I cannot let this latest blatant disregard for local people go unremarked.
Ref. N6/2013/1938/MA.

Title Proposed Materials

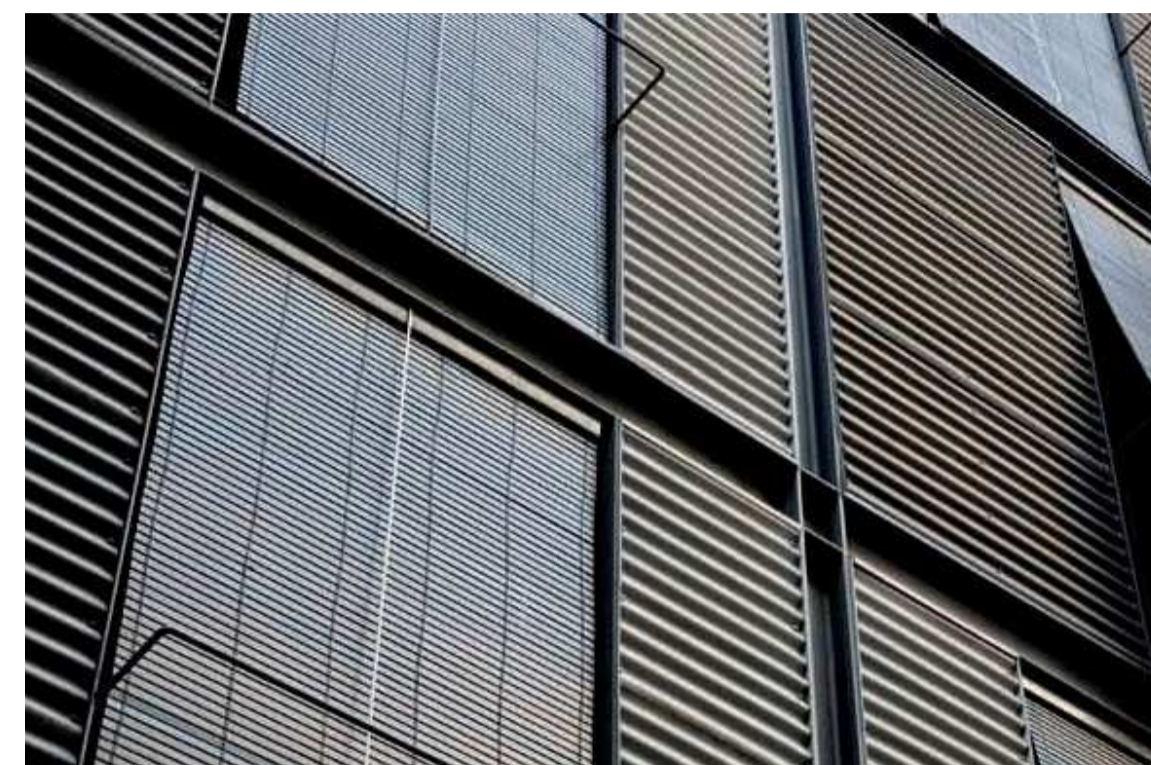
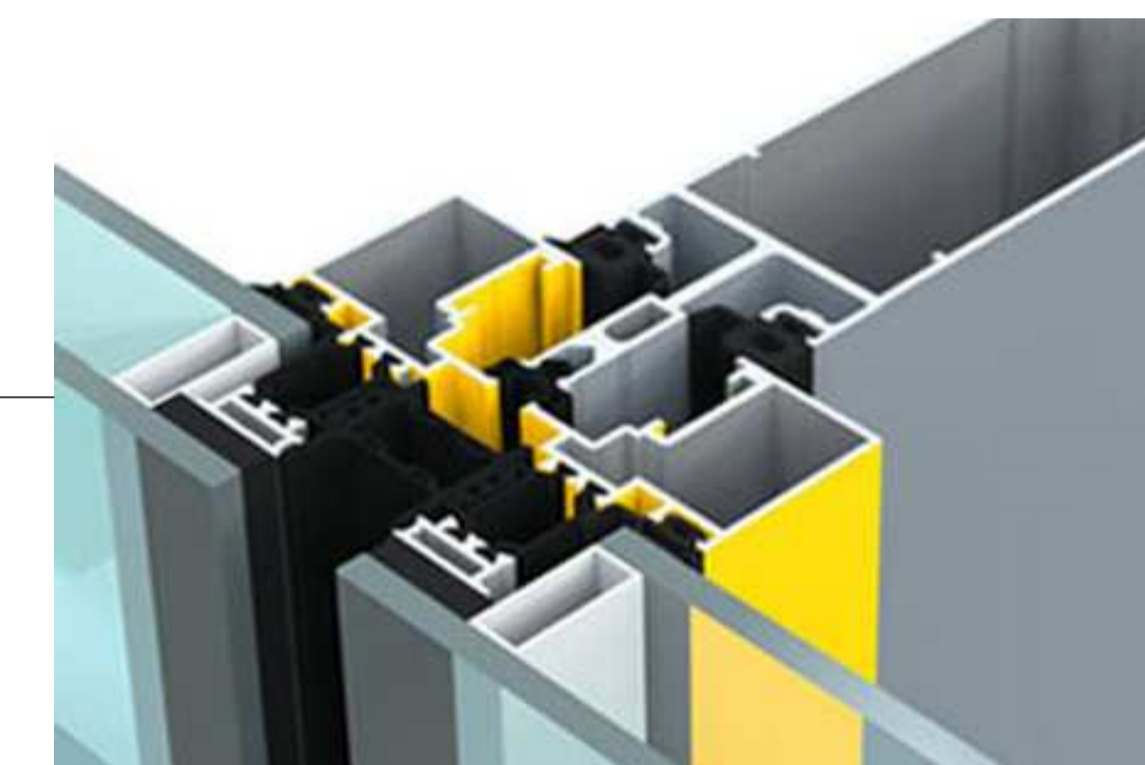
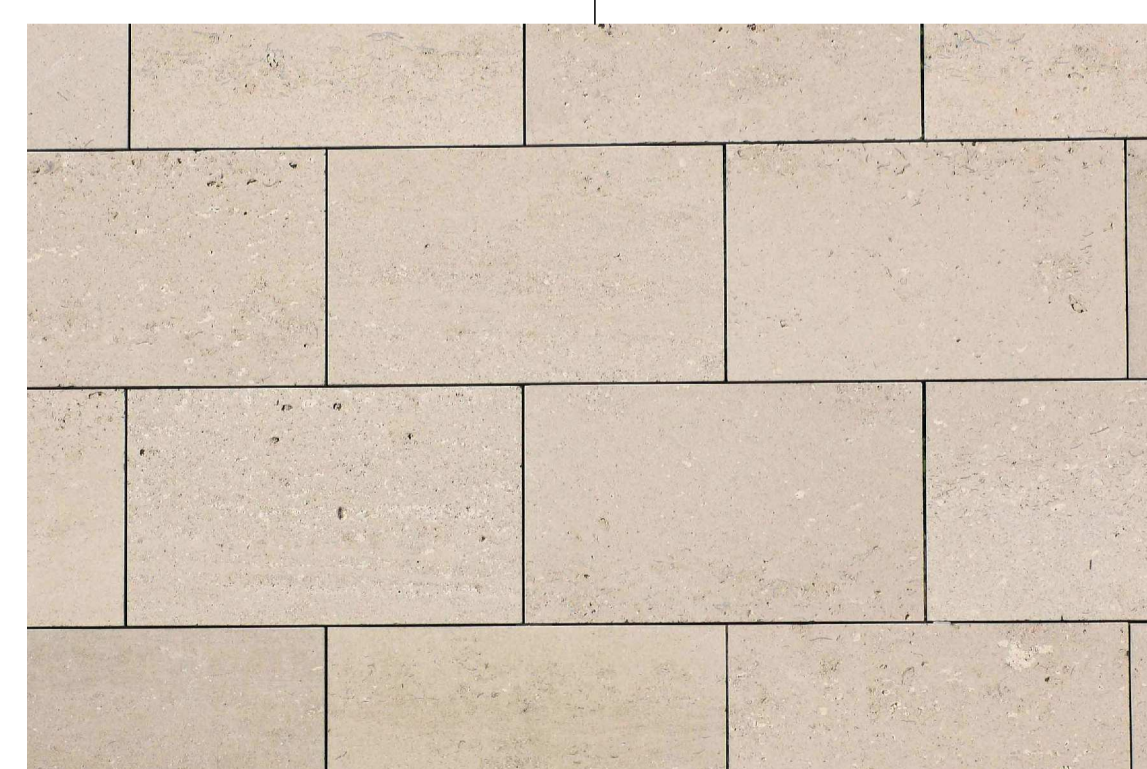
1. The exterior of the proposed offices do not respect the scale, design & materials of the original buildings facing the Campus
2. The Council's processing of its own planning application without any consultation is incredible. In this day & age it is to be expected that a public body is open & honest. This is certainly not the case with this proposed office development.
